COMPLETED 03/28/08 *SK*
DRB CASE ACTION LOG (PREL/FINAL)

DRB Application No.: 08DRB-70009

Project # 1007025

Project Name: ATLANTIC & PACIFIC ADDN

**PLAT OF
 LOTS A & B
 ATLANTIC & PACIFIC ADDITION
 PROJECTED SECTION 20, T. 10 N., R. 3 E., N.M.P.M.
 TOWN OF ALBUQUERQUE GRANT
 CITY OF ALBUQUERQUE
 BERNALILLO COUNTY, NEW MEXICO
 JANUARY, 2008
 SHEET 2 OF 2**

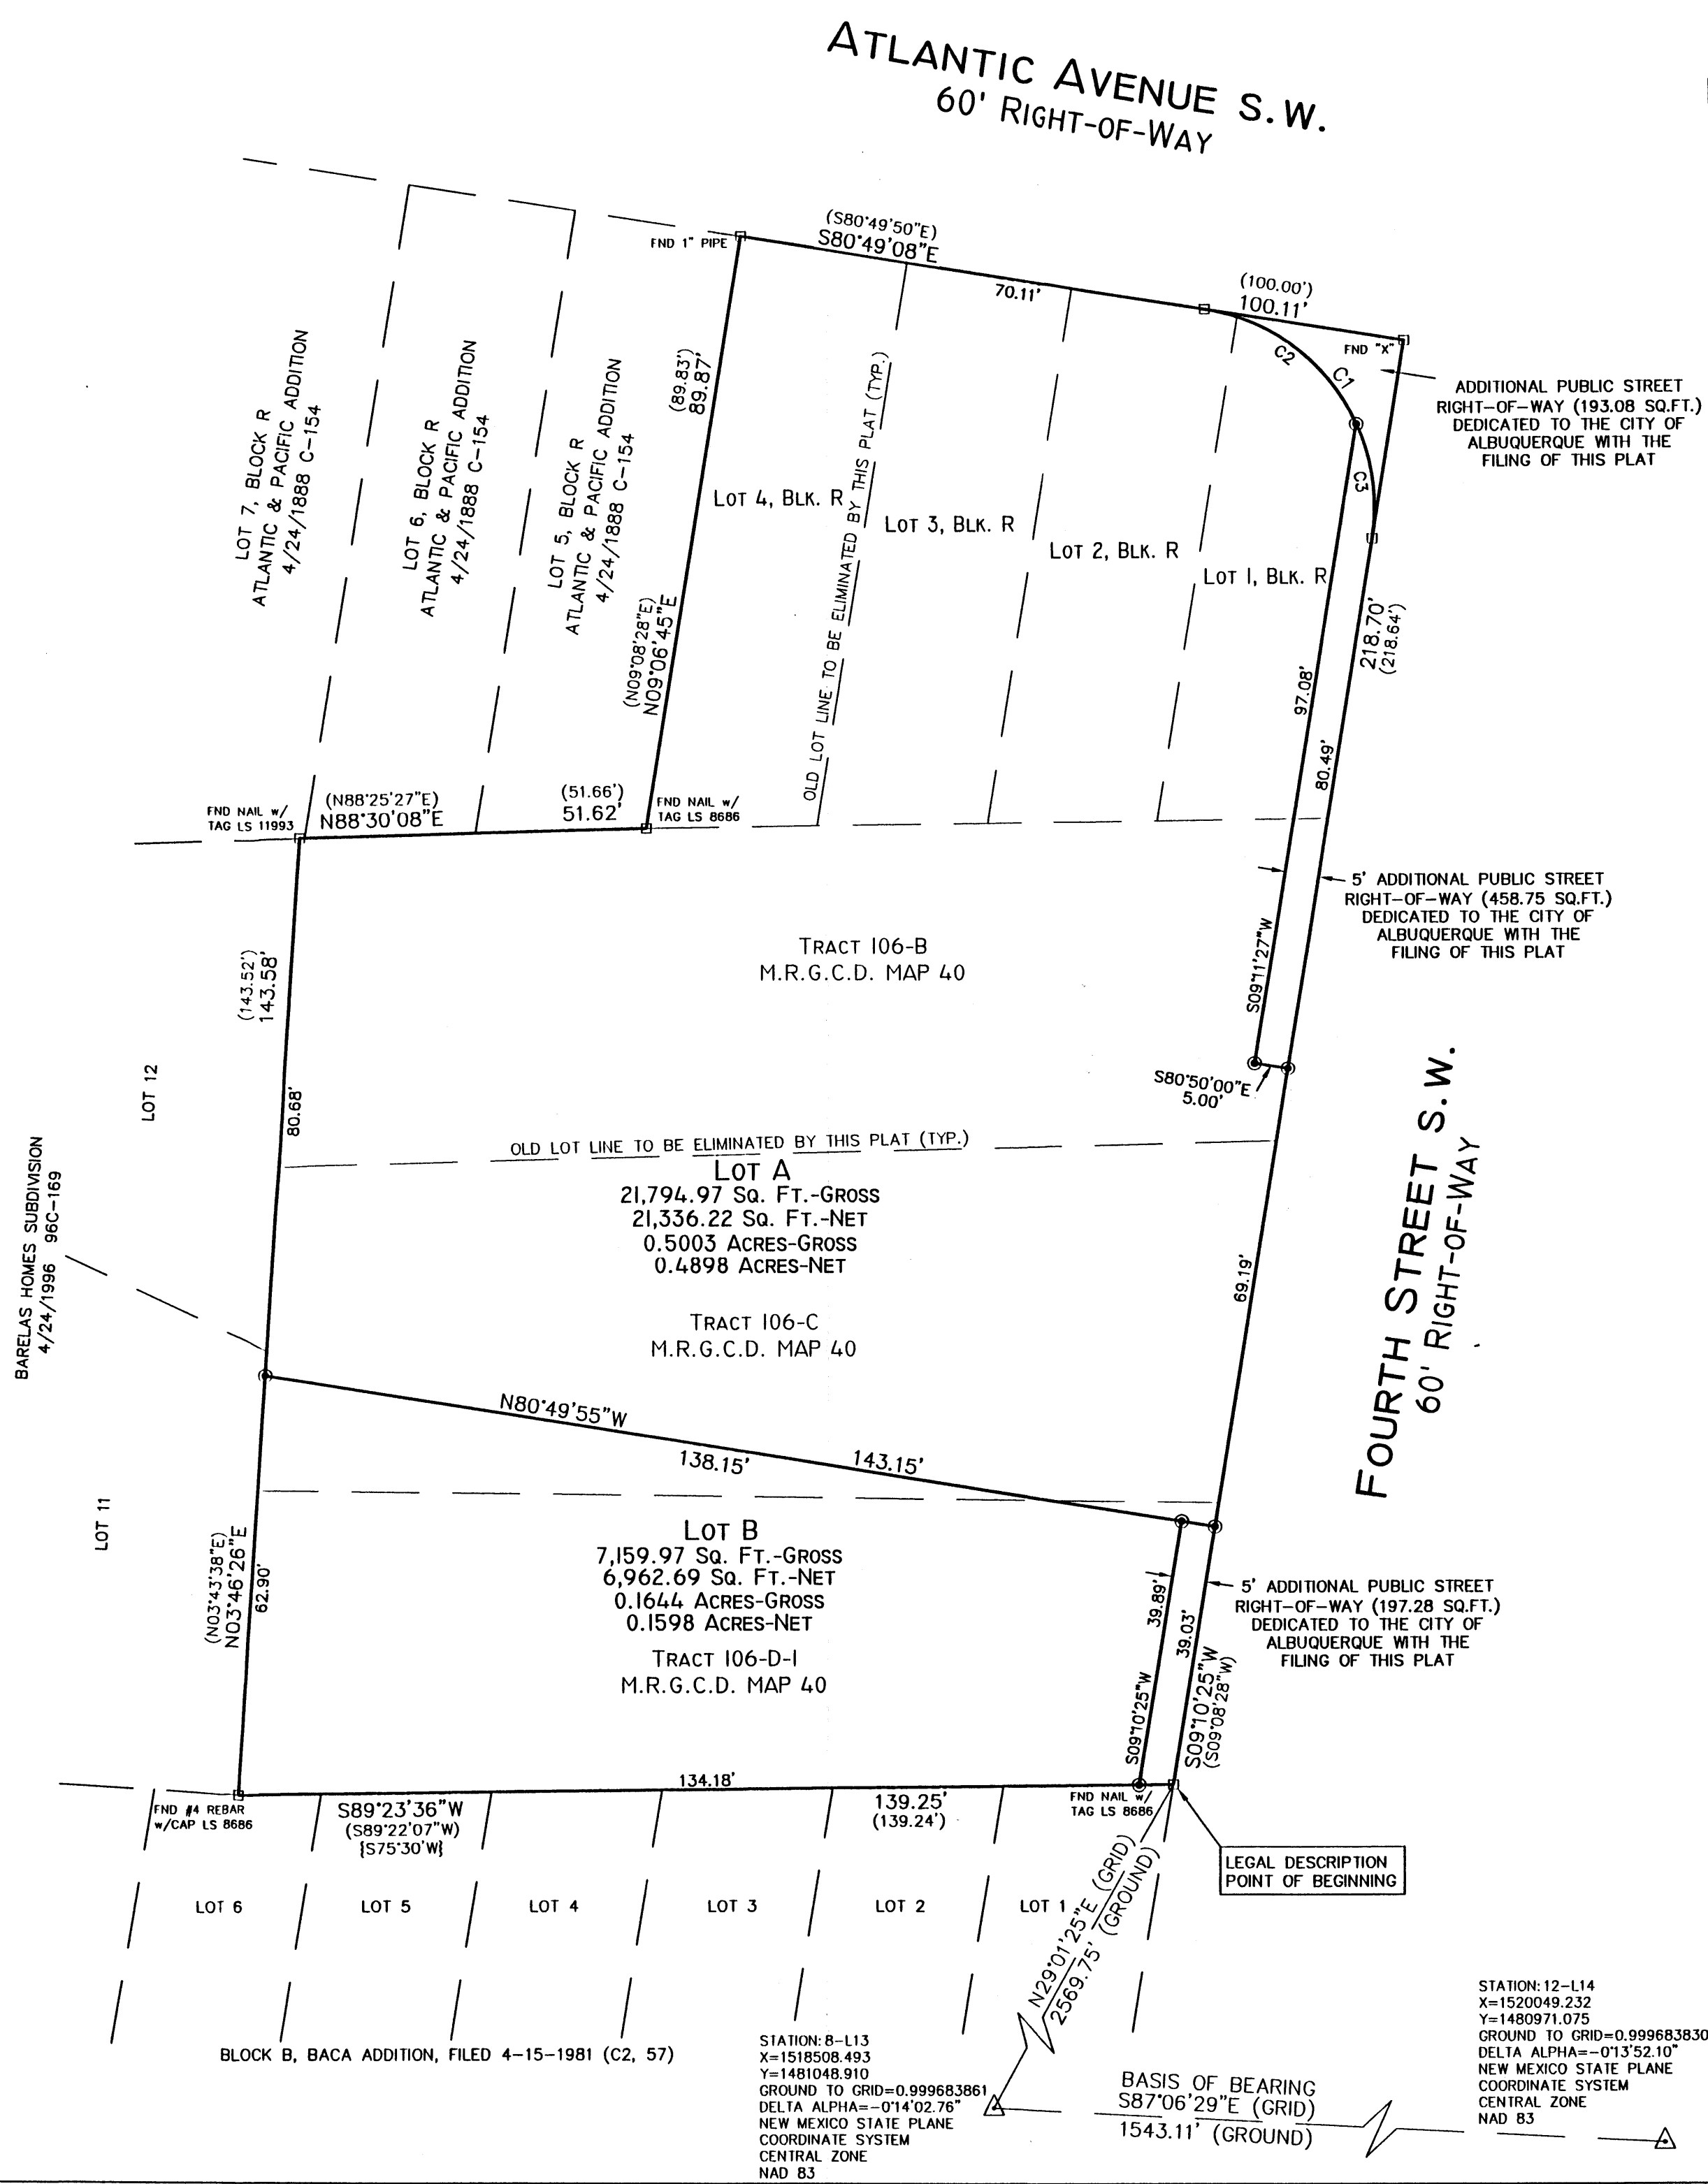
TRANSPORTATION: need exhibit showing dist from FC to PL; need 30' Radius at int of minor arterial and local roadway

TRANSPORTATION: need exhibit showing dist from FC to PL; need 30' Radius at int of minor arterial and local roadway
3/11/08 - can't sign - ROW dedication at curve must be defined
